From: Lawrence, Peter [REDACTED]
Sent: 17 August 2016 18:40
To: Claire Potts
Cc: Brindle, Heather
Subject: RE: Discharge of conditions application LU/96/16/DOC

I am the officer dealing with the above discharge of conditions (DOC) application for the Bovis Site at Hampton Park. Having reviewed some of the information submitted and some of the consultation responses received, please see my comments below:

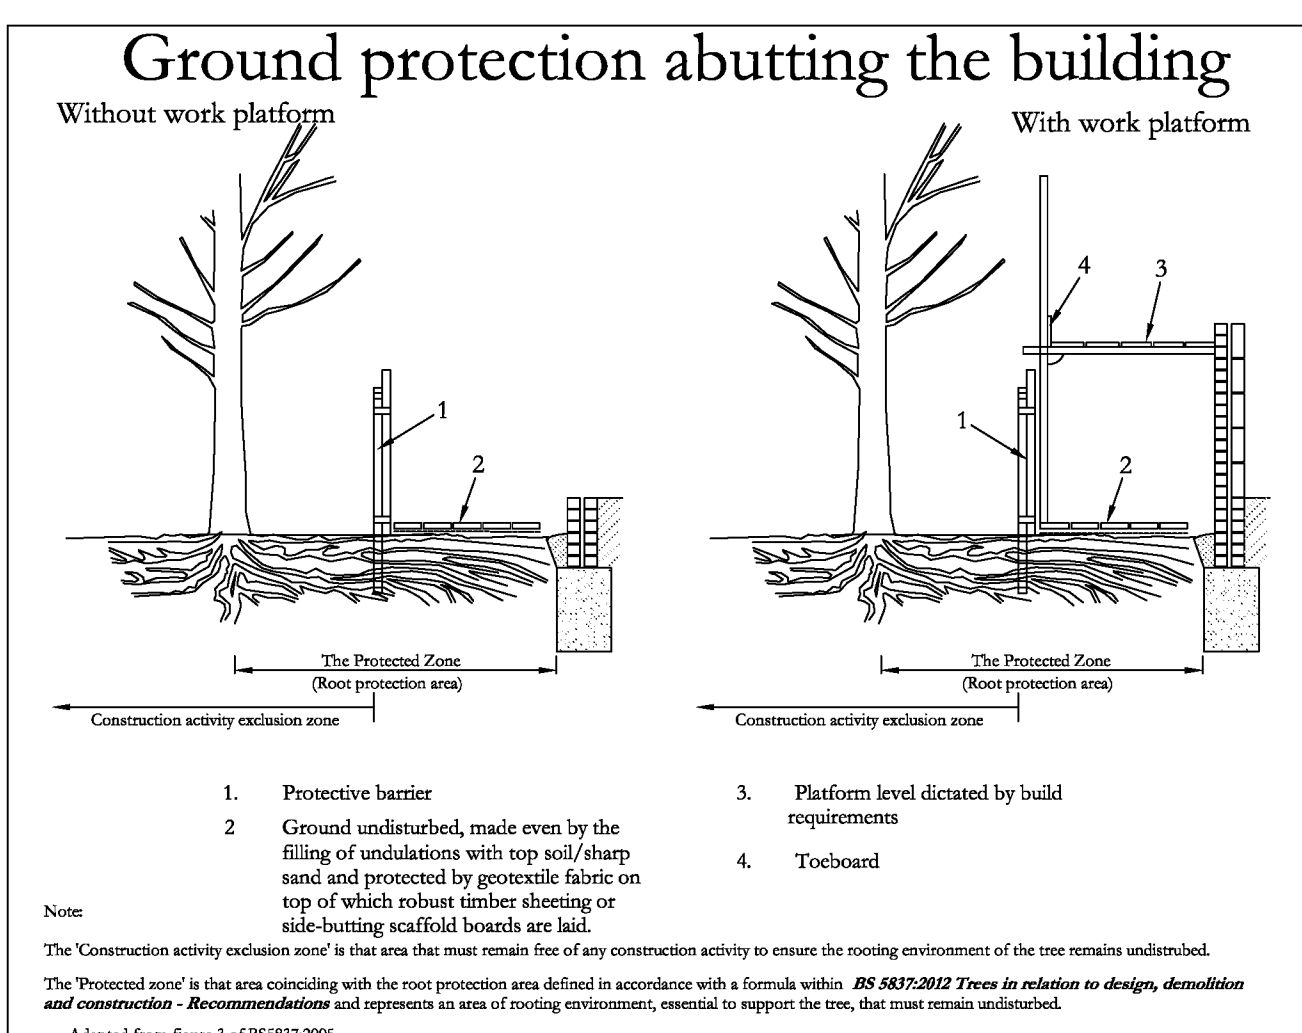
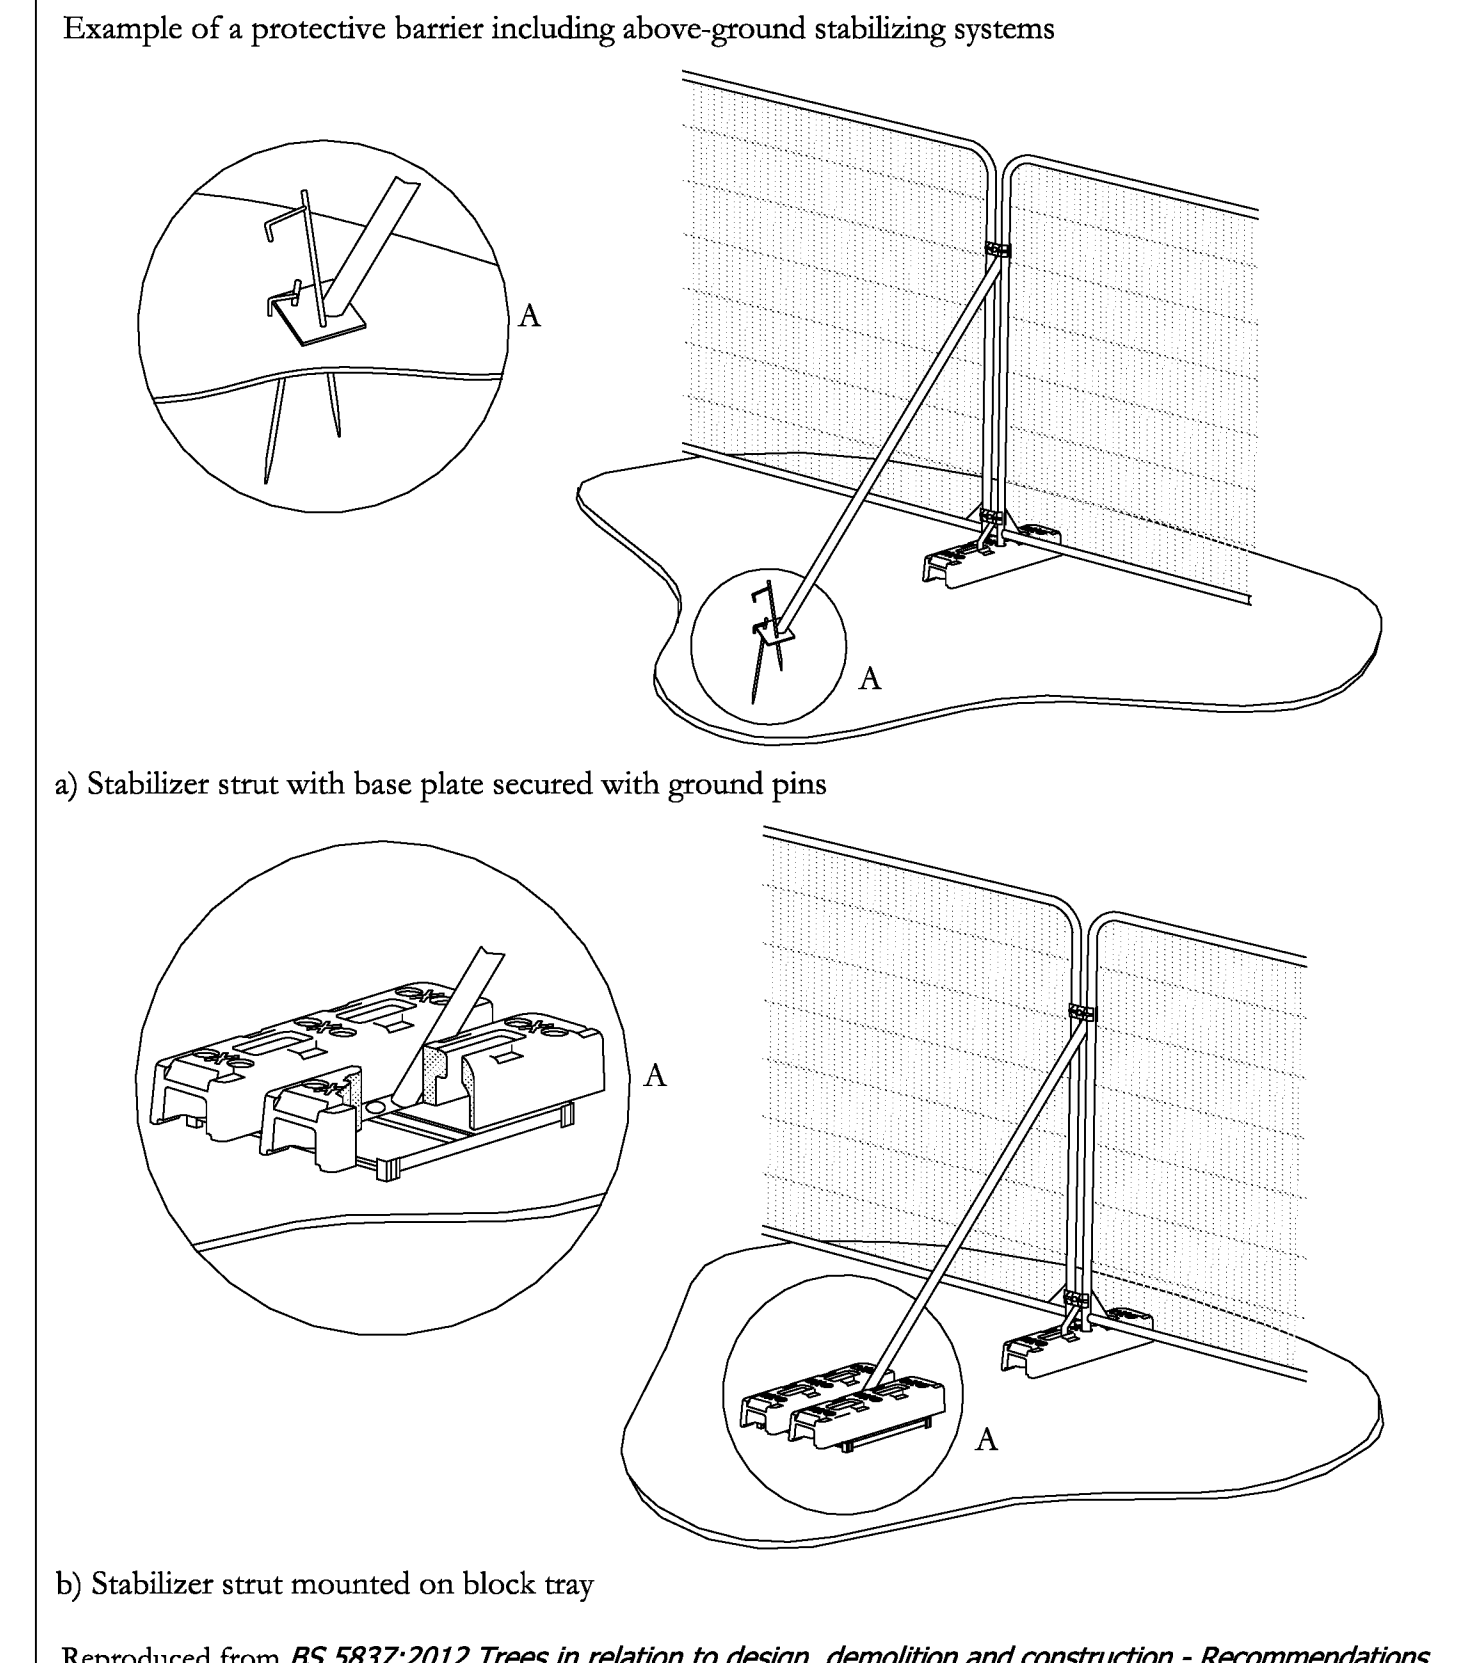
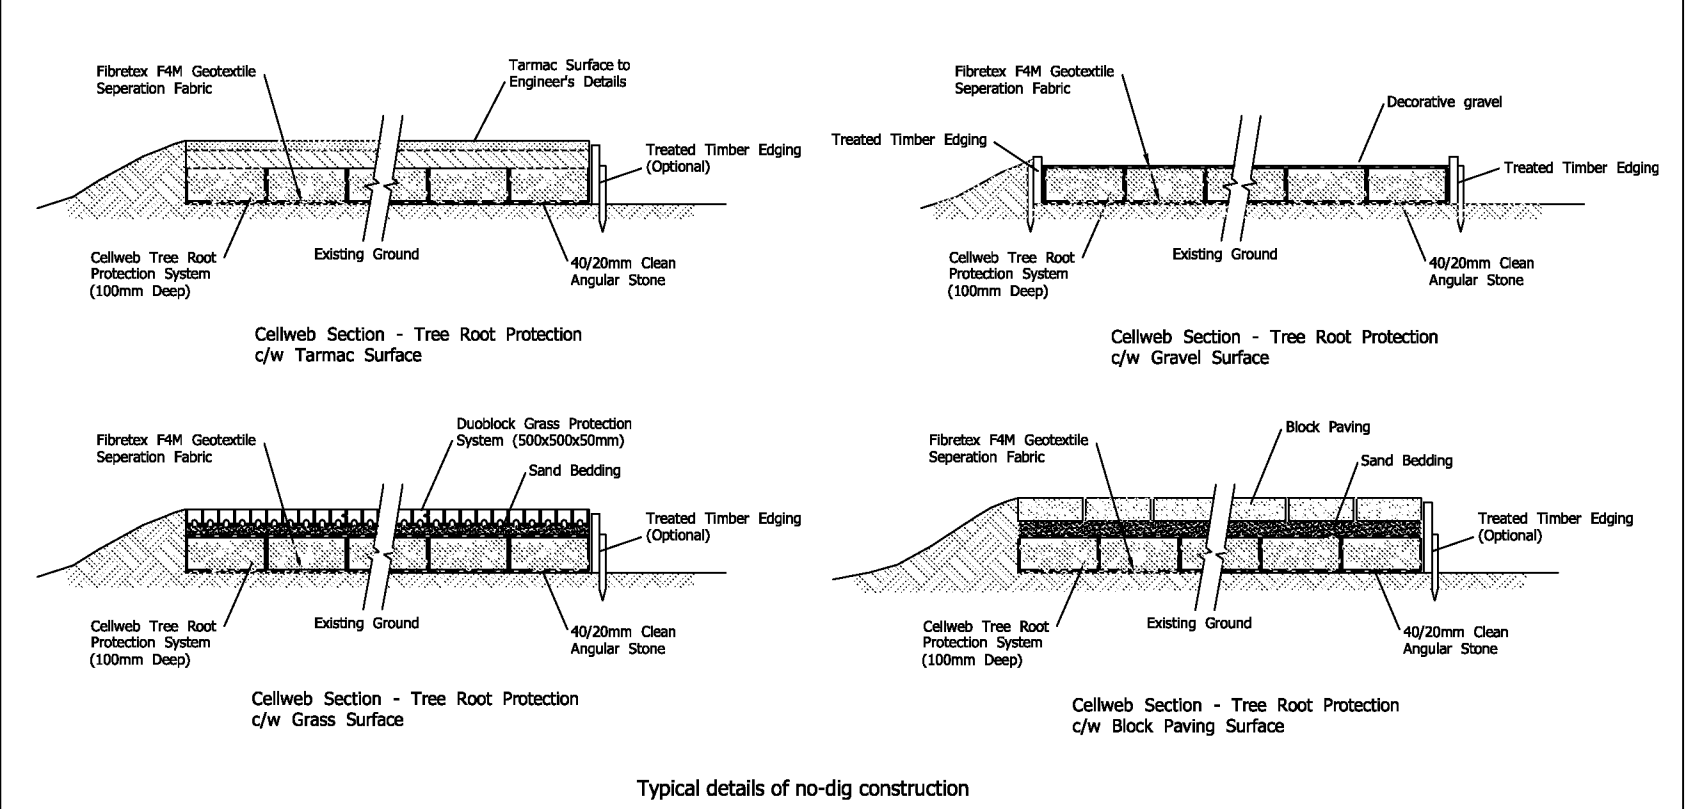
Conditions 14 (landscaping) and 15 (tree protection): the ADC Tree Officer has objected to the submitted information as a proposed dwelling (plot 25) is located within the Root Protection Area of T1. There is no method statement or mitigation measures on how this would be achieved in accordance with BS 5837:2012. Therefore, I will not be able to discharge this conditions until an acceptable method statement and mitigation measures are provided. Until this issue is resolved please ensure that the tree protection barrier around T1 aligns with the Root Protection Area, rather than the area illustrated on the submitted Plan. There has been no objection from ADC Landscaping officer on the soft landscaping scheme. **Please could you submit a revised plan and method statement to address the points raised and confirm that a tree protection barrier will be placed around the RPA of T1 with immediate effect.**

Claire they have re-surveyed the tree and I believe its location was incorrectly surveyed originally – fortunately it is well clear of the unit so protective fencing will be in place shortly.

See attached plan.
